From: Linda Griffiths
Sent: 02 January 2024 10:39
To: DC Support
Subject: FW: 23/03073/HYBRID - Phase 2 SW Bicester Kingsmere Parcel R East Of, Ludlow Road, Bicester

Subject: 23/03073/HYBRID - Phase 2 SW Bicester Kingsmere Parcel R East Of, Ludlow Road, Bicester

Heavy Standard Tree Pit Detail - Staked

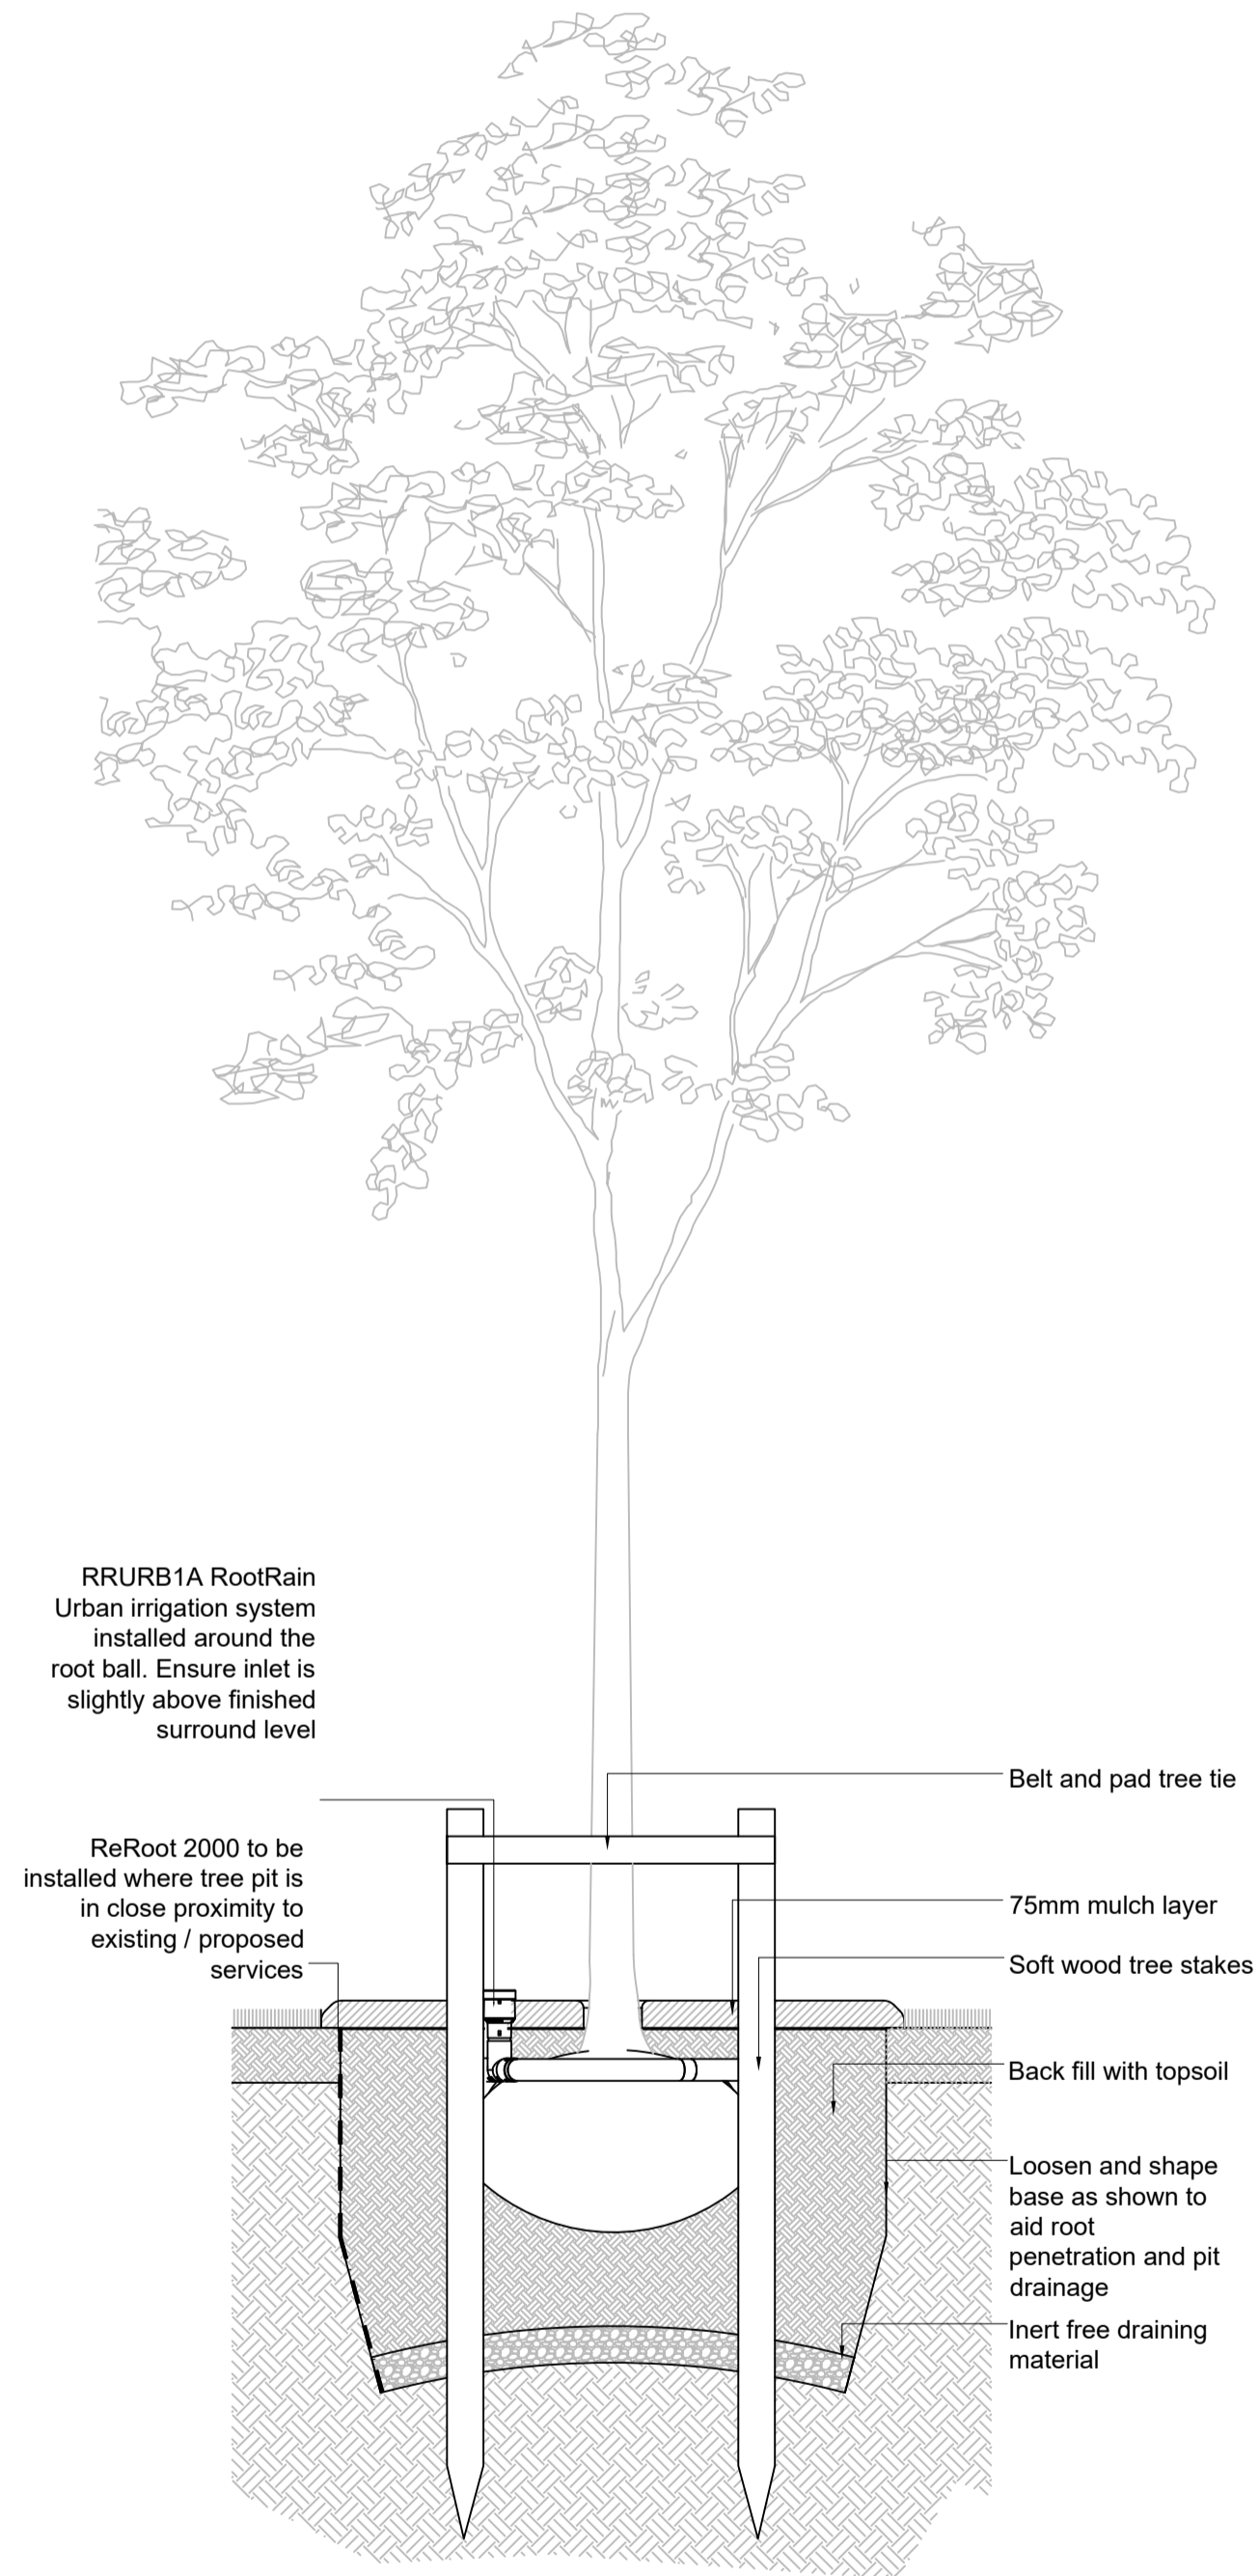
The indicative design layout on the Proposed Site Layout Plan is generally acceptable as a basis for a detailed hard and soft landscape proposal drawing with implementation and aftercare notes, planting schedules, plant/tree sizes and groundcover planting densities and boundary treatments. Tree pit details in hard and soft areas are required in accordance with BS8545: 2014 (root defectors should be considered).
